From: Nicola Spencer on behalf of Planning.Responses
Sent: 18 March 2022 18:10
To: Planning Scanning
Subject: FW: BR/17/22/PL

I have concerns over the impact of odour and noise resulting from the extraction system on the residential premises above the proposed development. If the applicant cannot demonstrate there shall be no negative impact on neighbouring residents, Environmental Health does not support this proposal.

SCHEMATIC DIAGRAM OF A KITCHEN VENTILATION SYSTEM LEGEND

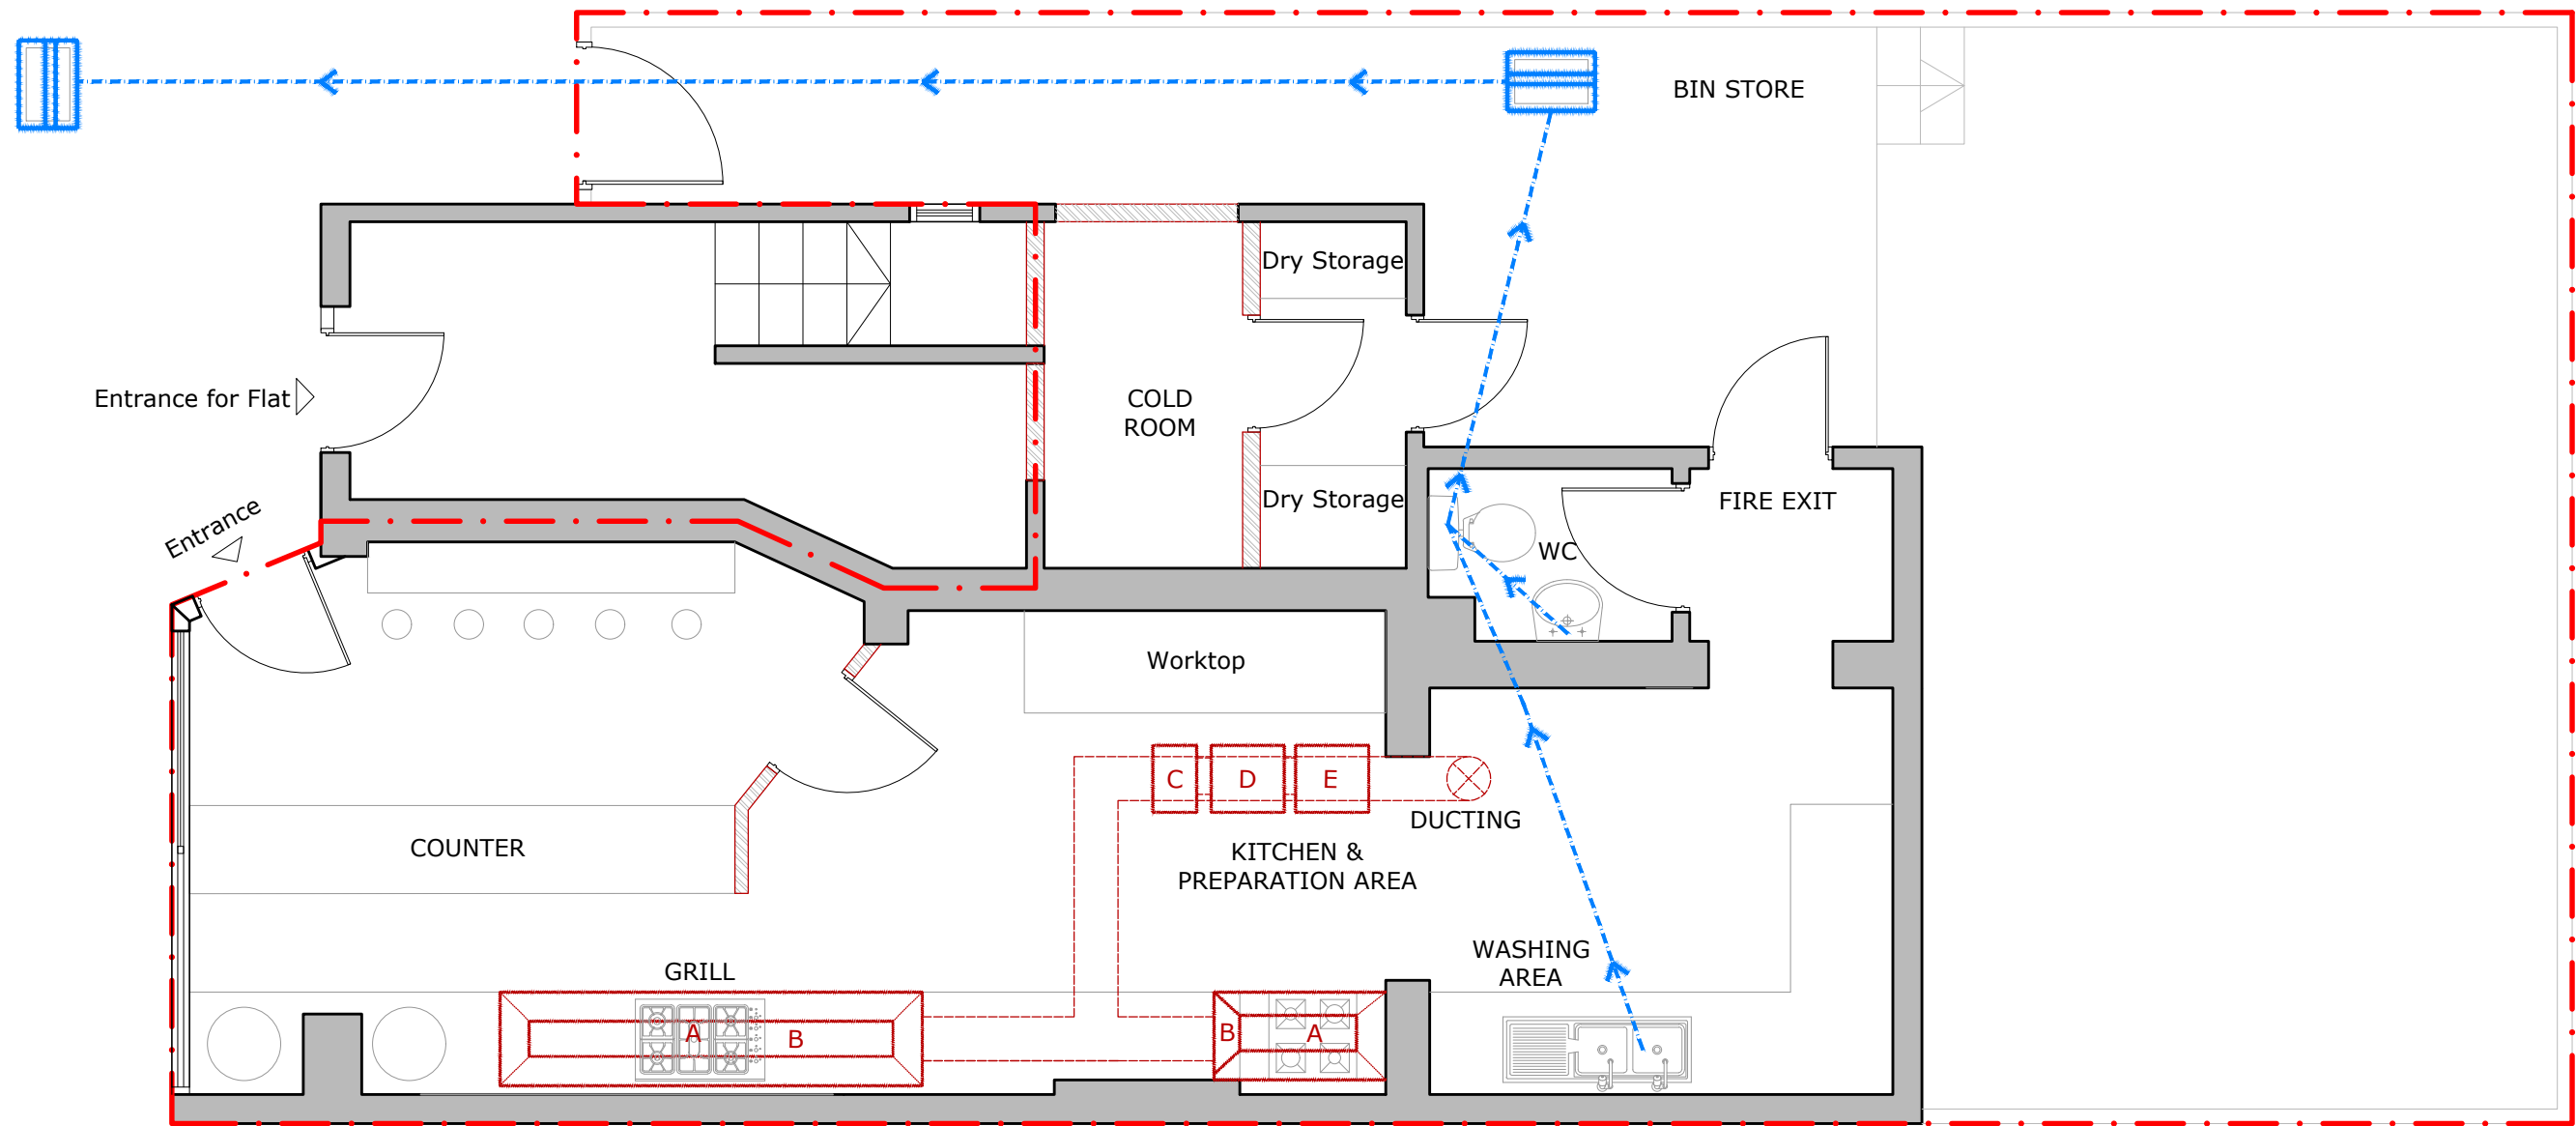
Without the requested information Environmental Health objects to the application based on the likelihood that the extraction shall have a negative impact on the amenity of local residents, and is likely to give rise to statutory nuisance.
